# PROPOSED CHANGES APPLICATION REPORT

## Drax Bioenergy with Carbon Capture and Storage

**Document Reference Number: 8.5.1**

**Applicant: Drax Power Limited**

01-xx Amended Book of Reference Plot Number

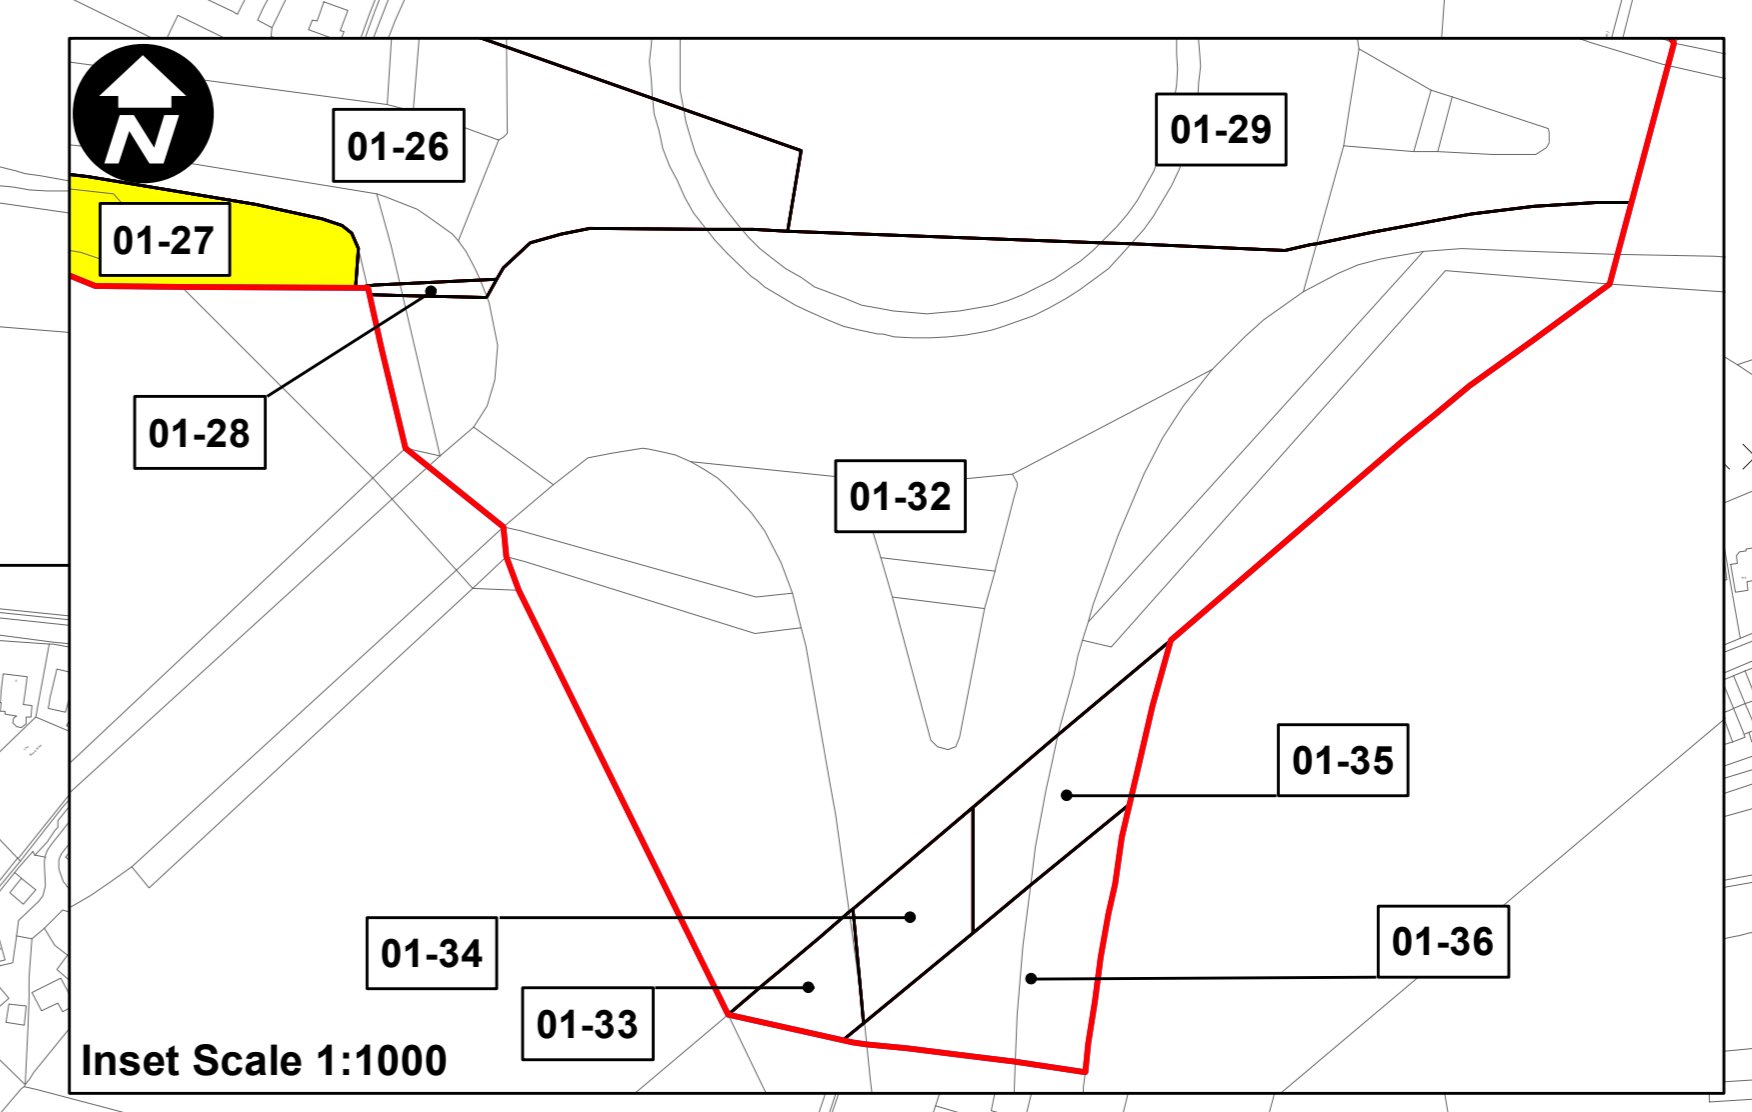
- b. Proposed Change 02 ('PC-02'): Relocation of existing overhead lines in respect of two electrical lines (11kv overhead line crossing the A645 once, owned by Northern Powergrid ('OHL1'), and 11kv overhead line crossing Rawcliffe Road once, owned by Northern Powergrid ('OHL2')) and the Telecommunications line crossing Rawcliffe Road twice, owned by Openreach ('TCL1'), which cross the access route to the Site at A614 (Rawcliffe Road) and the A645, to allow for the delivery of Abnormal Indivisible Loads (AILs) to the Site. This Proposed Change involves land that is outside of the current Order Limits and is not in the ownership of the Applicant.

- 2.1.18. Following submission of the Application, further technical work and ongoing discussions with the owner of the affected Lines (Northern Powergrid and BT Openreach), has identified that the following works may be needed to resolve the conflict between the AIL movements and the Lines:

- a. Undergrounding is the preferred approach, but that as a consequence, a slight realignment of the retained Lines and restringing works may also be necessary;

- b. Undergrounding needs to take place for the section of the electrical lines which is supported by telegraph poles, i.e. from 'pole to pole', rather than just for the section of line which sits over the highway. This requires land outside of the highway boundary;

DRAWING TITLE  
8.5.2.4 - FIGURE 4 – OHL LANDSCAPE AND BIODIVERSITY PLAN – SHEET 1 OF 2

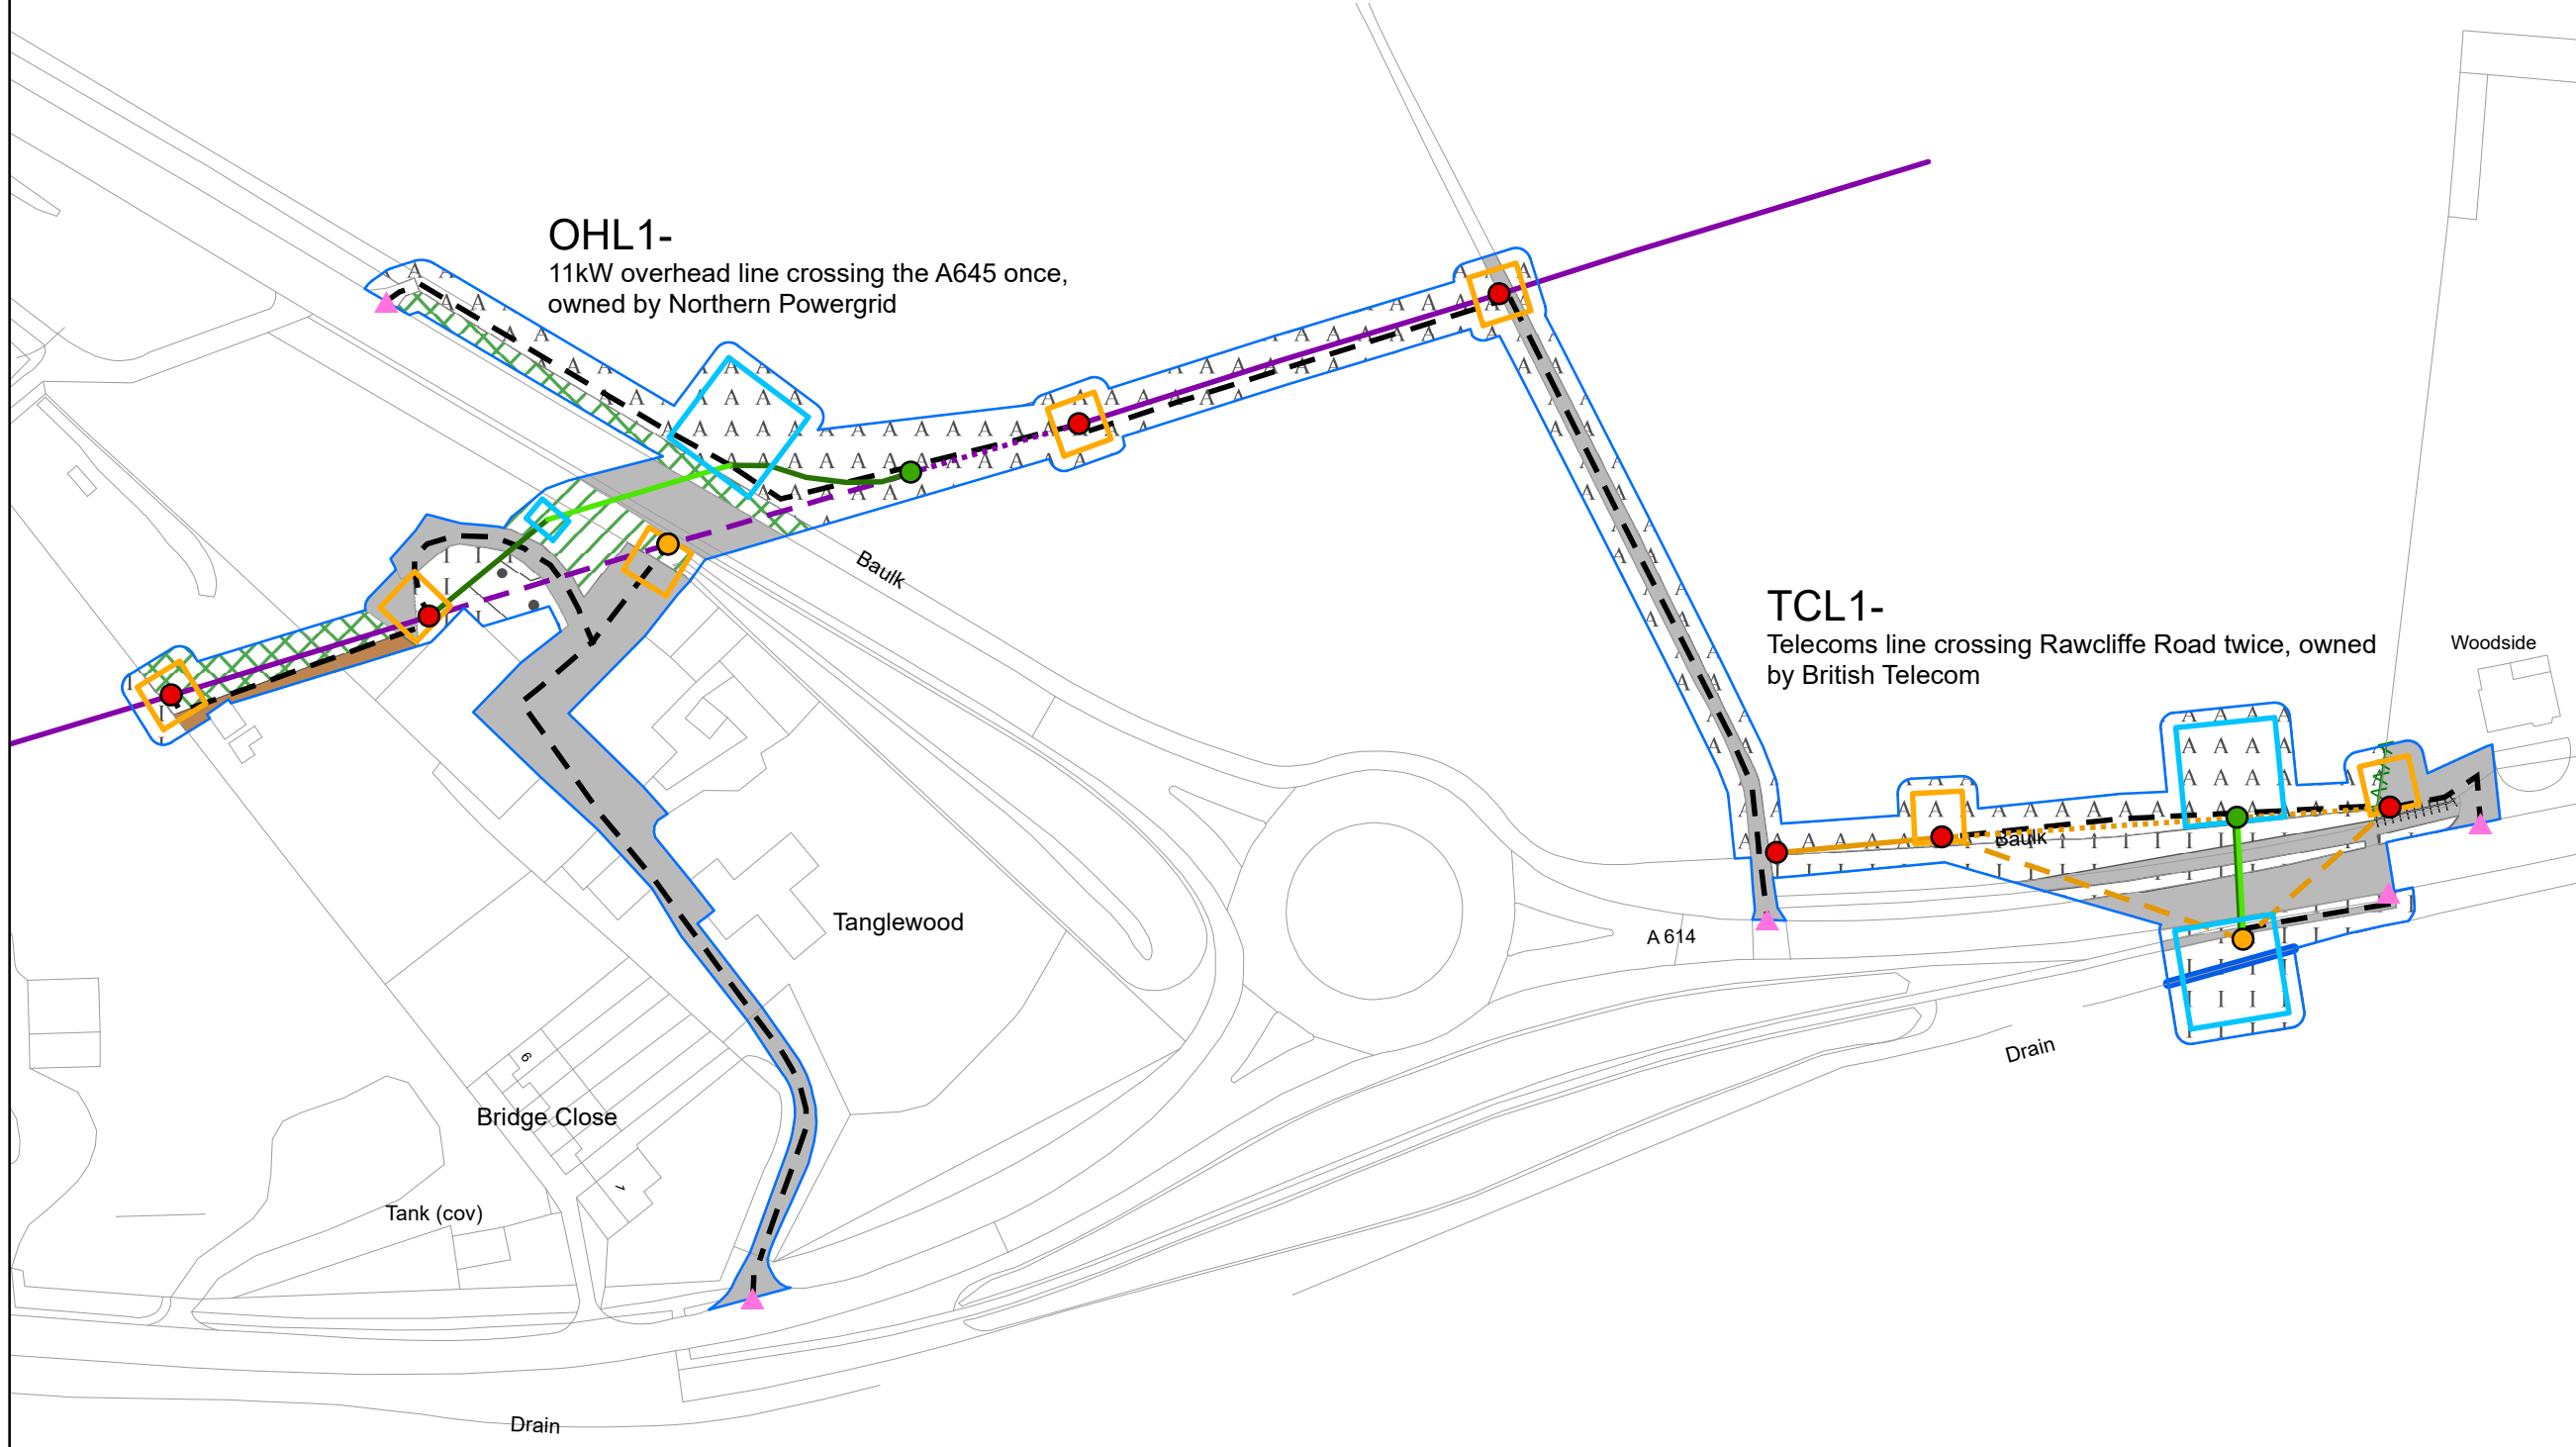
- c. Undergrounding of the electricity and telecommunications lines could be undertaken via horizontal directional drilling (HDD), similar techniques such as thrust boring or auger boring, or open trenching methods, as appropriate for sections of the cable routes; and

Drawing file: EN010120 / EN010120-001292-8.5.2.2 Figure 2 to PCAR – Overhead Line (OHL) Constraints Plan Rev02.pdf

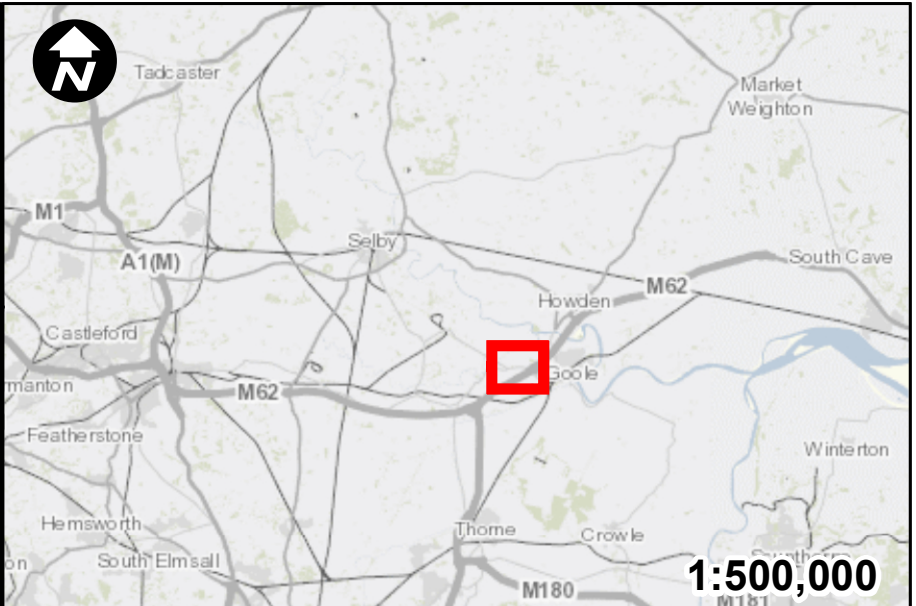
- 2.1.17. The proposed access route for AILs is shown in Figure 5.6 of the ES (APP-067) and is restricted by two existing electrical lines and the telecommunications line which cross the access route to the site at the A614 (Rawcliffe Road) and the A645.

- d. Third party land outside of Drax's ownership would be required to access the poles and undertake the works. Furthermore, as the position of the electrical cables, be they undergrounded or realigned lines, may be different to the route of the existing lines, DCO land powers will be needed to enable the installation of the altered alignment of the electrical cabling (be they via undergrounded sections or lines), and to access and maintain the altered sections of electrical and telecommunications lines in the future.
